RE: AUSTRALIAN MUSEUM - ALTERATIONS AND ADDITIONS  
SSD 9452

On 22 October 2018, the Department of Planning and Environment requested the Government Architect NSW (GANSW) provide an independent design review of the Australian Museum (AM) Alterations and Additions (SSD 9452). In conducting the review, GANSW has considered the EIS prepared by Ethos Urban, dated 4<sup>th</sup> October 2018 (including its appendices), as well as the advice previously provided to the proponent through the State Design Review Panel (SDRP) which is chaired by GANSW.

FLOOR PLAN - LOADING DOCK - PROPOSED  
AM ADDITIONS & ALTERATIONS

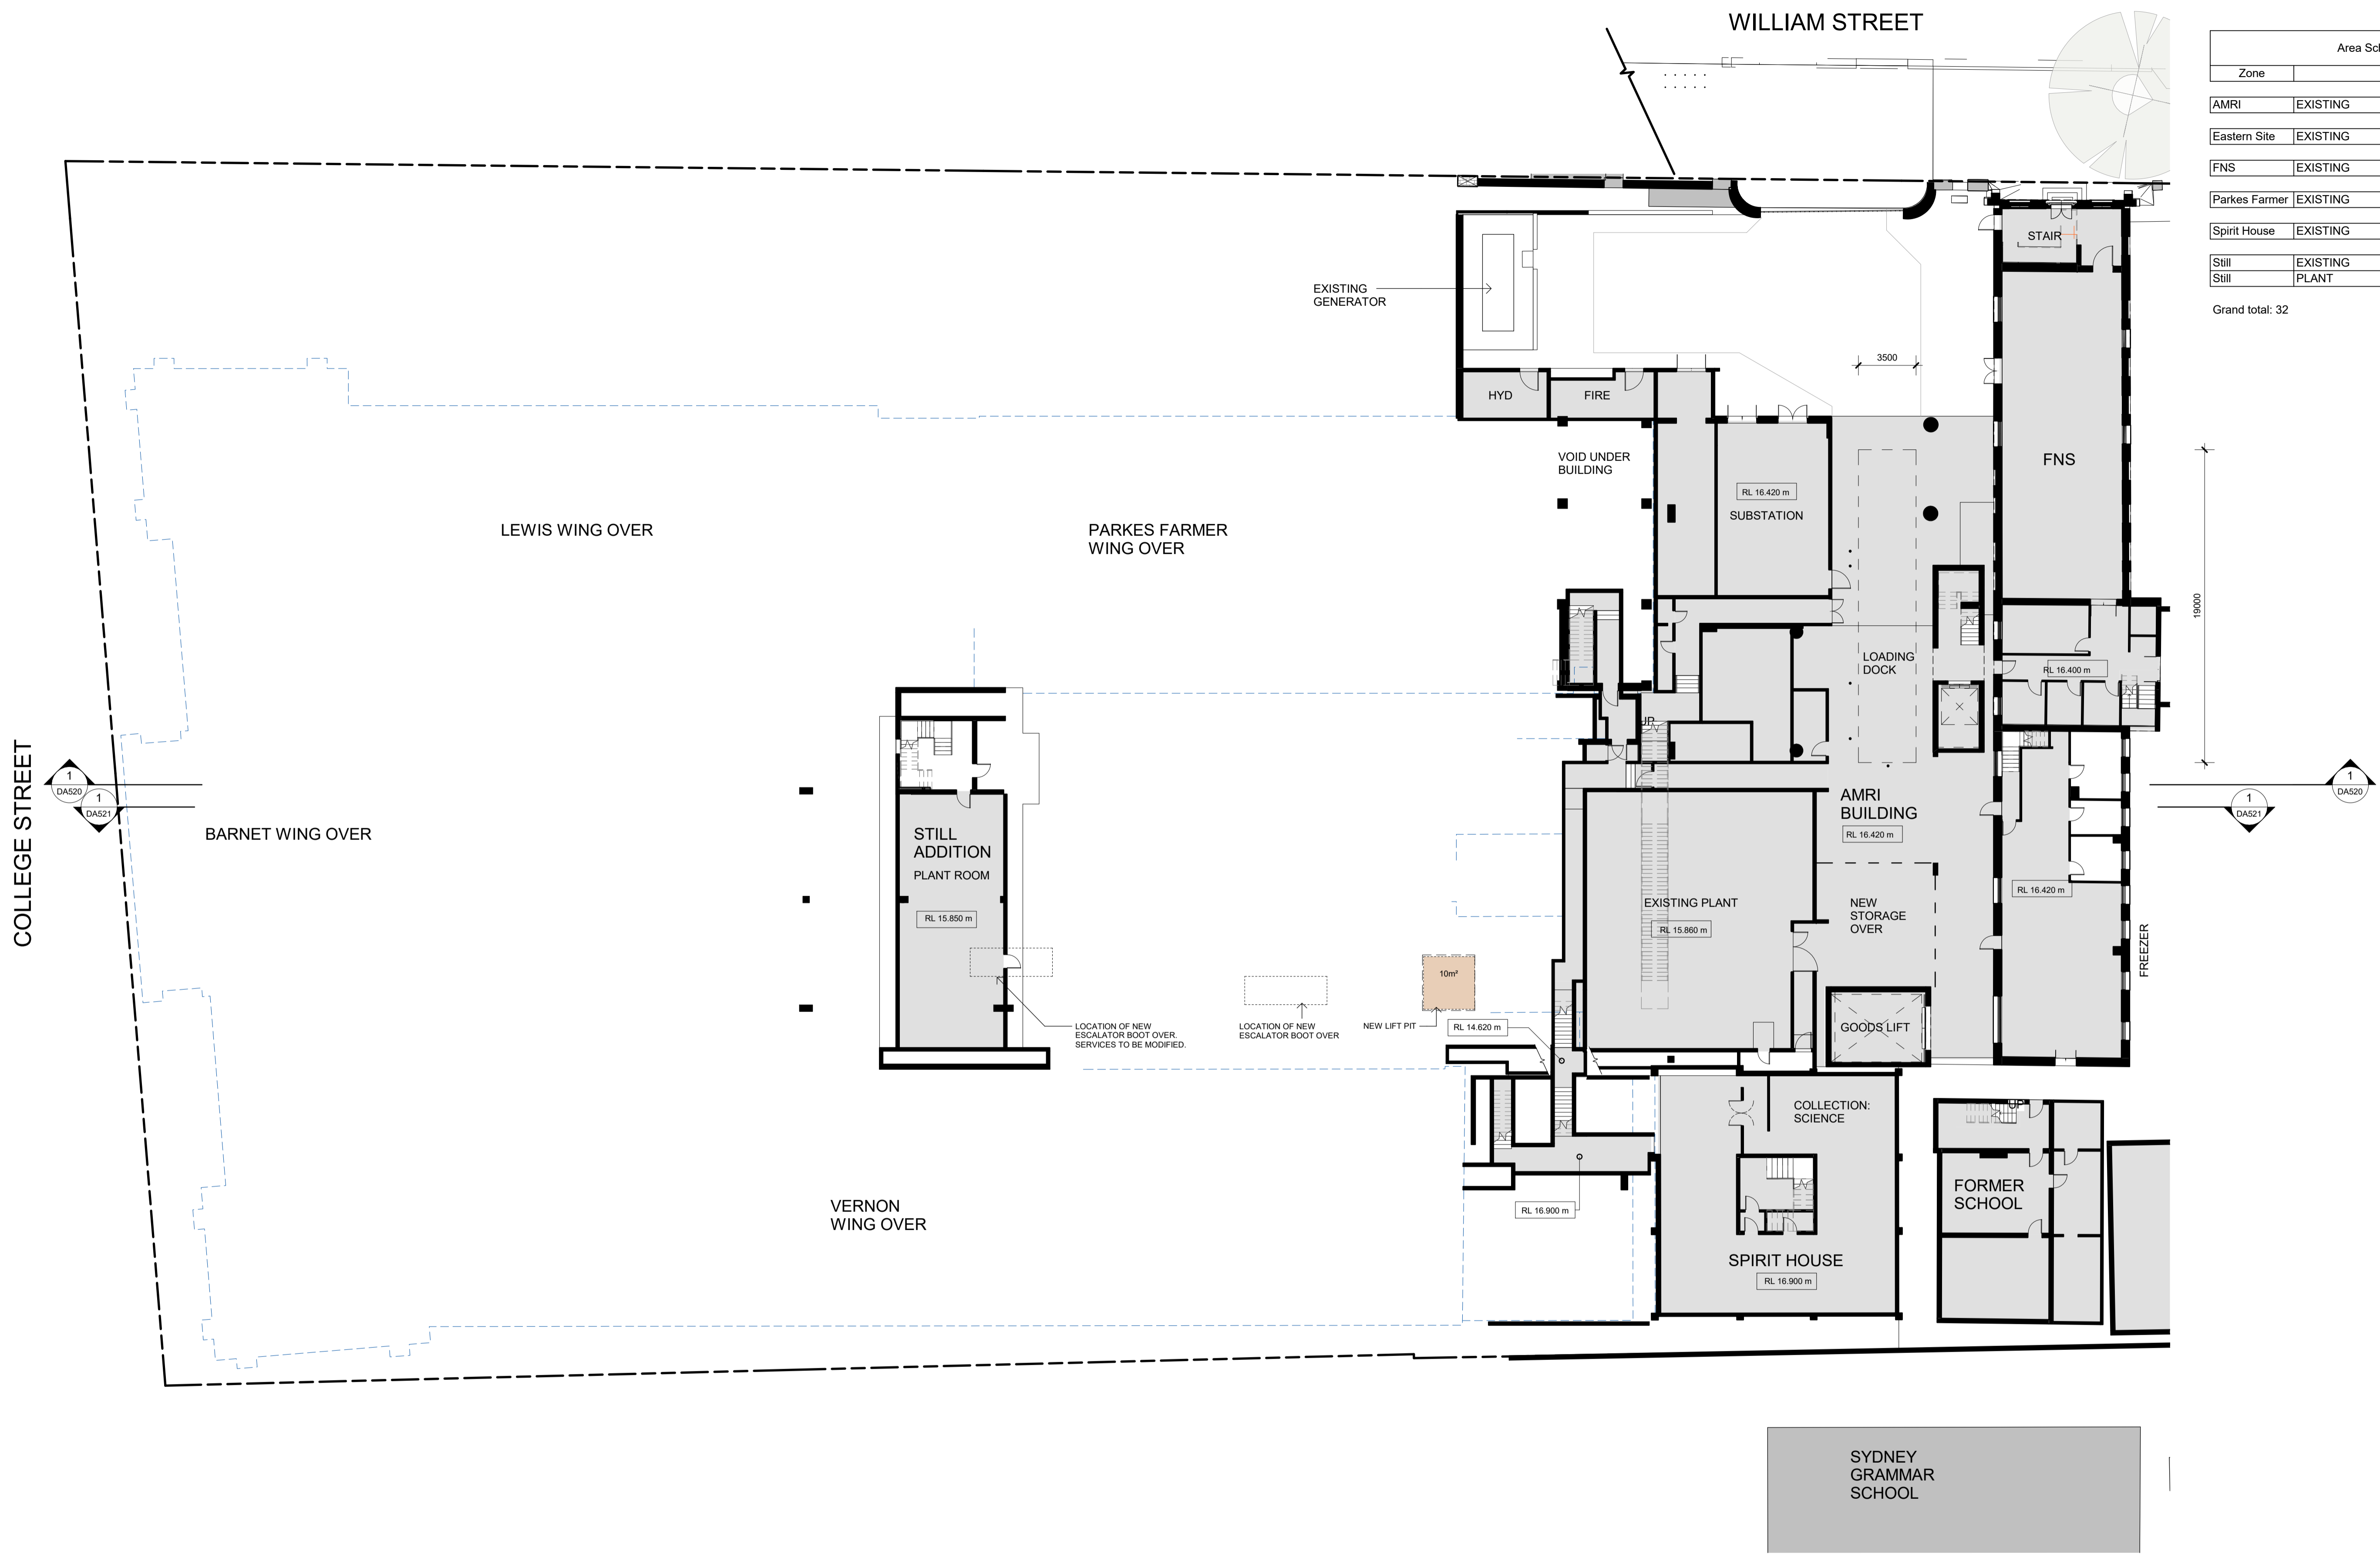
The proposal does not demonstrate how the capacity of the existing loading dock facilities are appropriate to service the expanded exhibition area, in a safe, secure and functional manner given the value of the artefacts to be displayed and Work health and safety considerations. As raised in SDRP letter dated 30 August 2018, the existing loading dock was noted to not meet international standards.

FLOOR PLAN - BASEMENT LEVEL - PROPOSED  
AM ADDITIONS & ALTERATIONS

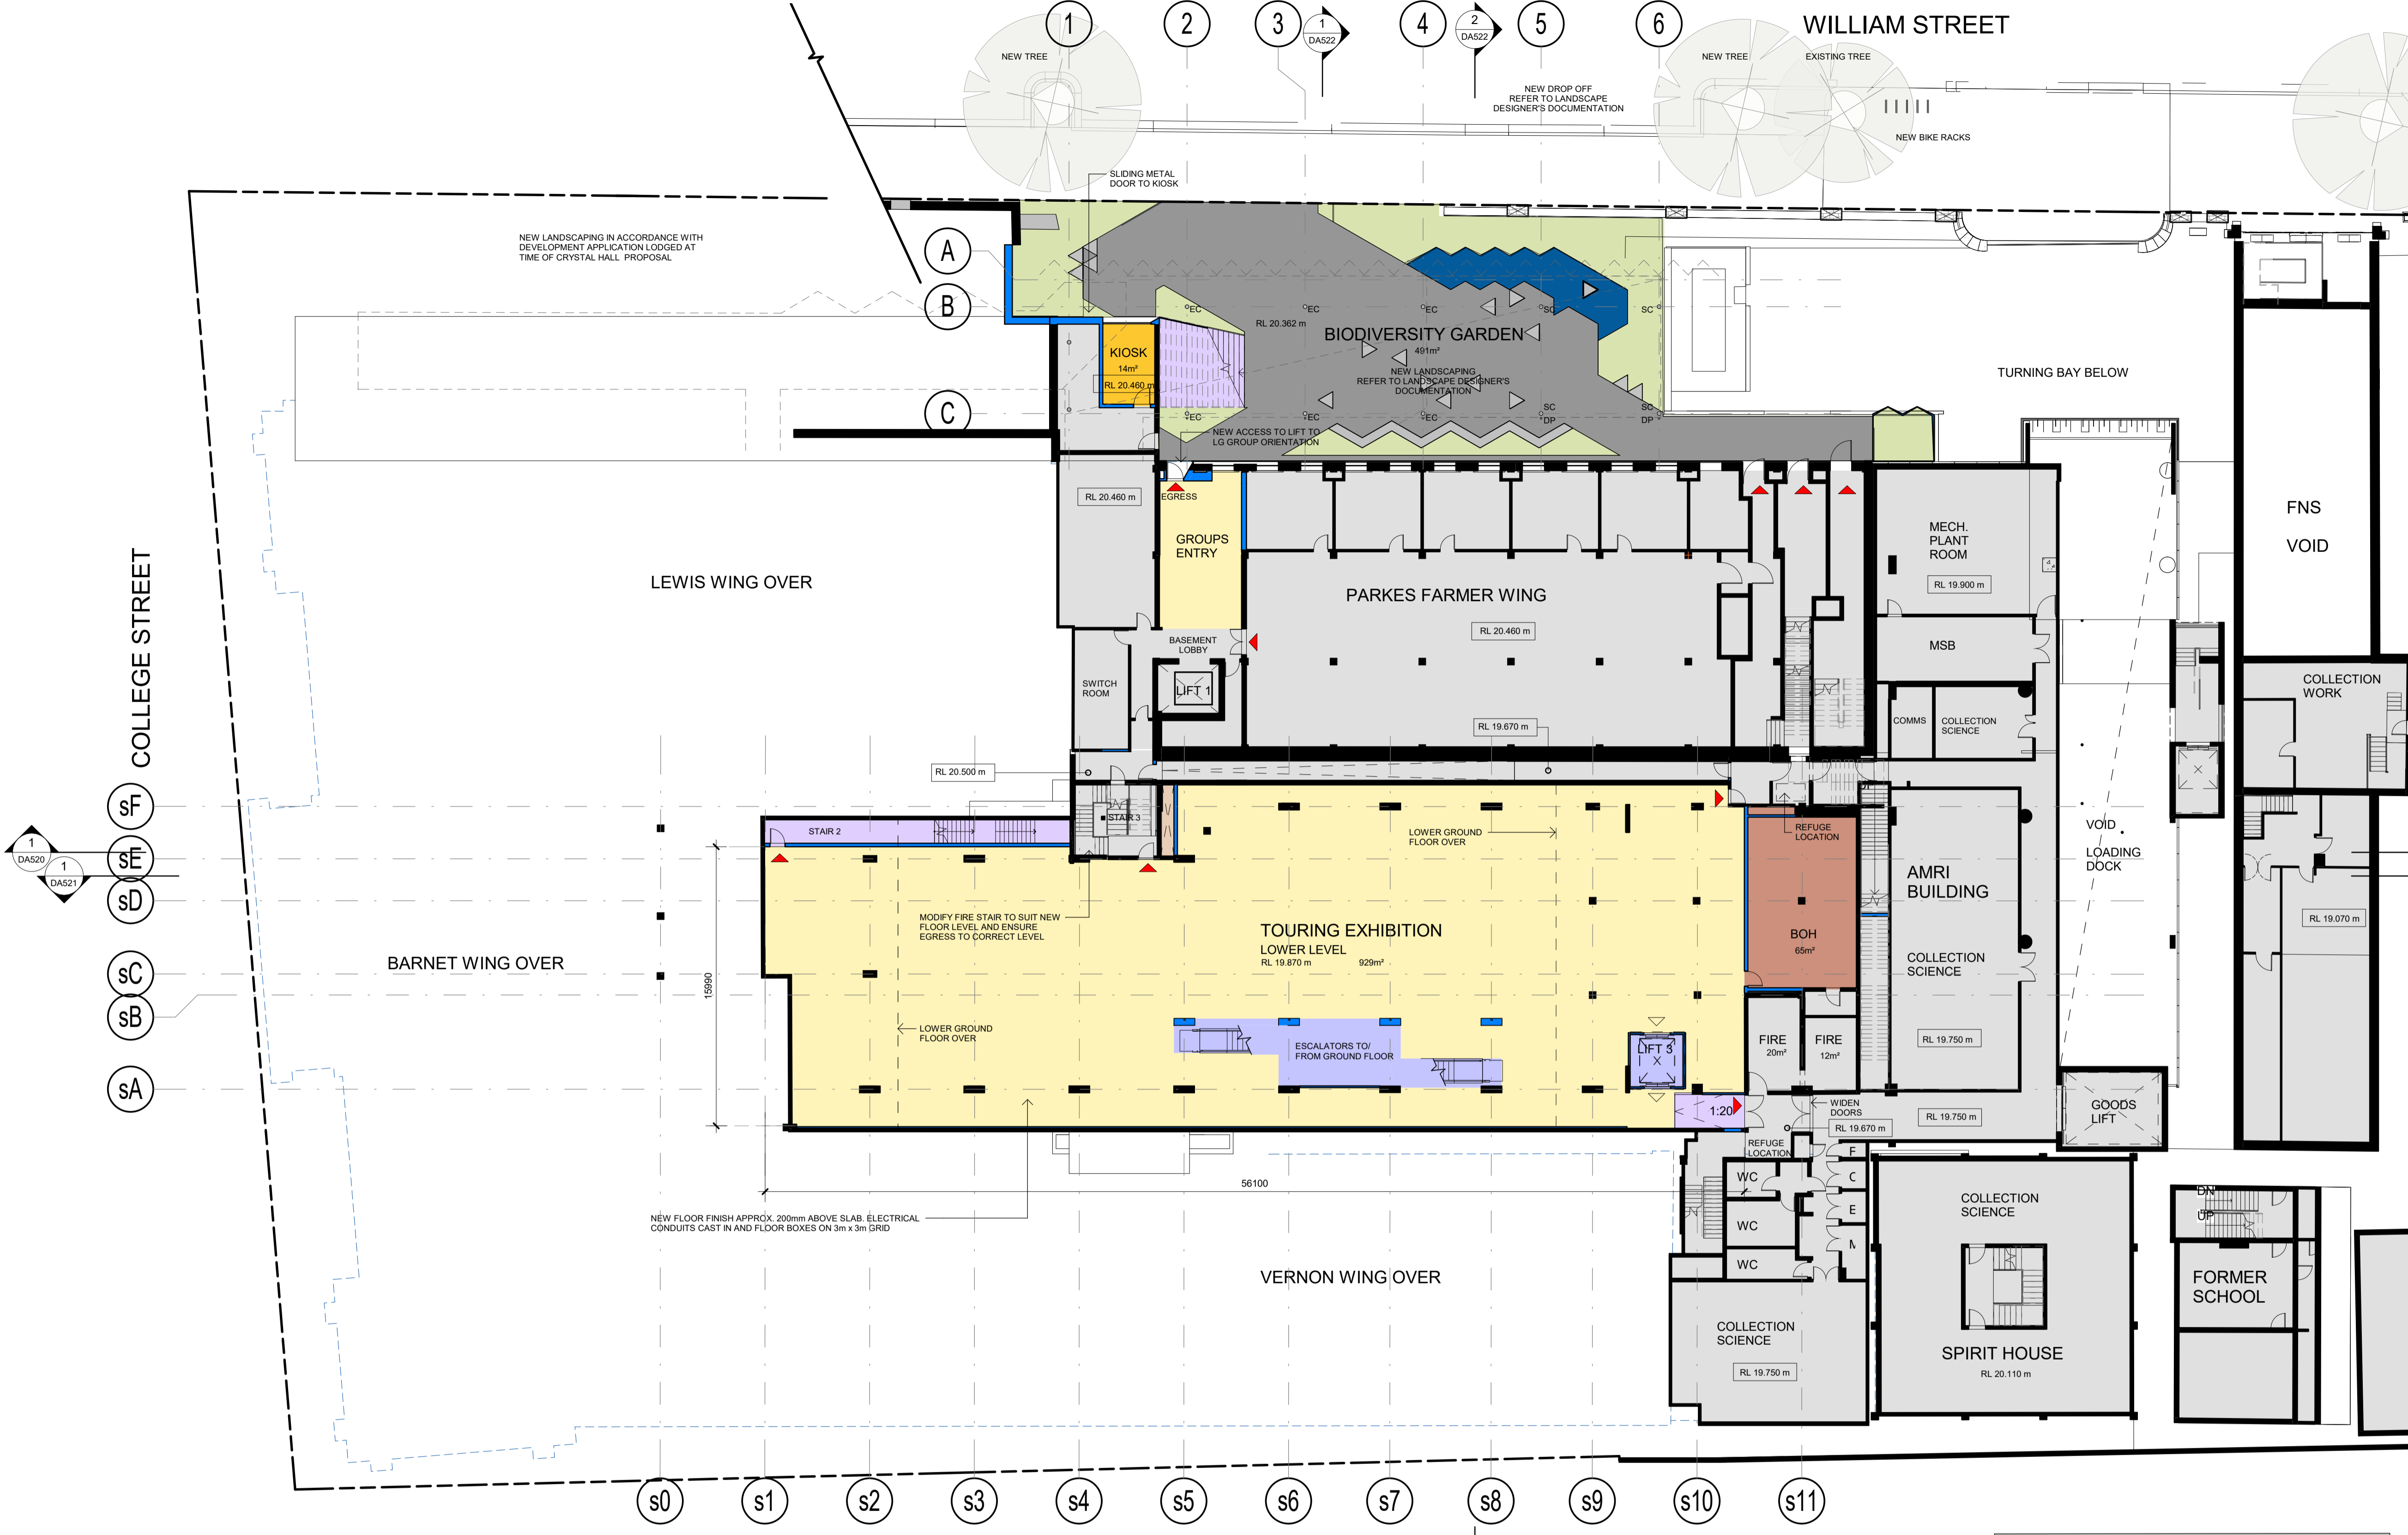
In addition, further information should be provided by the proponent on the specifications, materials, details and integration of the escalators and new lift between the Great Hall and the Basement level touring exhibition spaces, including detailed interior elevations and sections.
